**Re: DIV21315 – 326-328 South Circular Road, Dublin 8, Dublin– Diversion enquiry.**

Irish Water has reviewed your enquiry in relation to the diversion of existing 225mm concrete foul main and 150mm DI water main to facilitate the new housing development at 326-328 South Circular Road, Dublin 8, Dublin as indicated on drawings 1023 rev. PL4, 1032 rev. PL5 & 1120 rev. PL3.

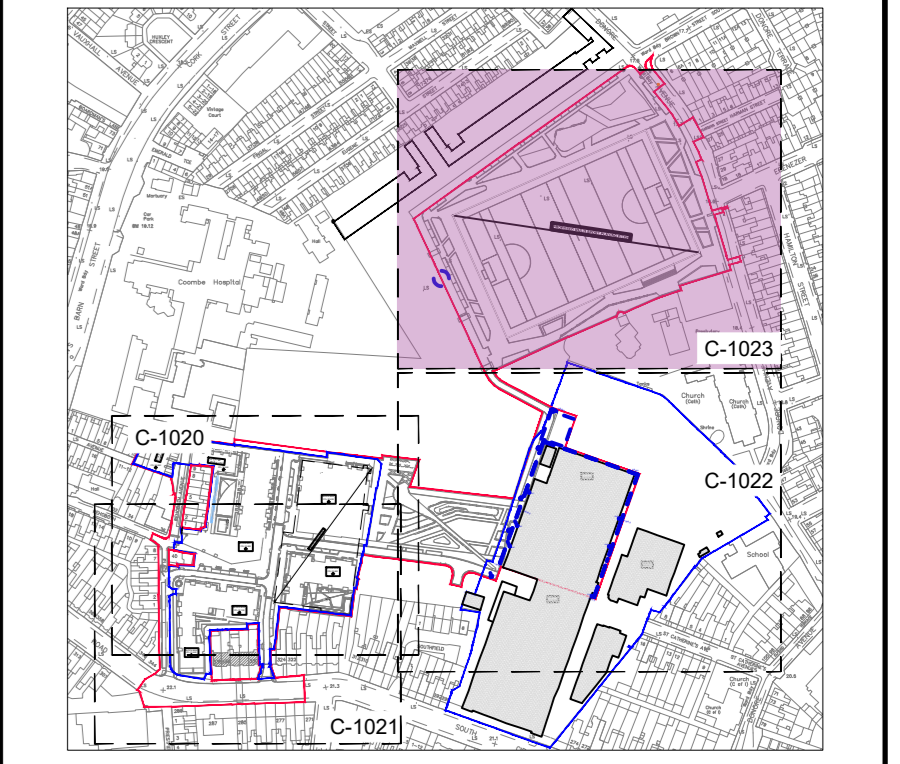
Based upon the details you have provided with your enquiry and as assessed by Irish Water, we wish to advise you that, in this instance, Irish Water will accept the proposed diversion of existing 225mm concrete foul main with new 300mm uPVC foul main and existing 150mm DI water main with new 150mm HDPE water main to accommodate the new housing development. Subject to the conditions set out below being in place.

1. The construction shall be constructed in strict accordance to drawings 1023 rev. PL4, 1032 rev. PL5 & 1120 rev. PL3.
2. Applicant has to upgrade the existing 300mm to 375mm foul crossing road main section on Donore Ave.
3. Applicant has to register new wayleaves over the new diverted mains.
4. Coombe Women and Infants University Hospital is being fed from the proposal 150mm DI water main. Hospital will need to be notified in advance for the proposal diversion works.
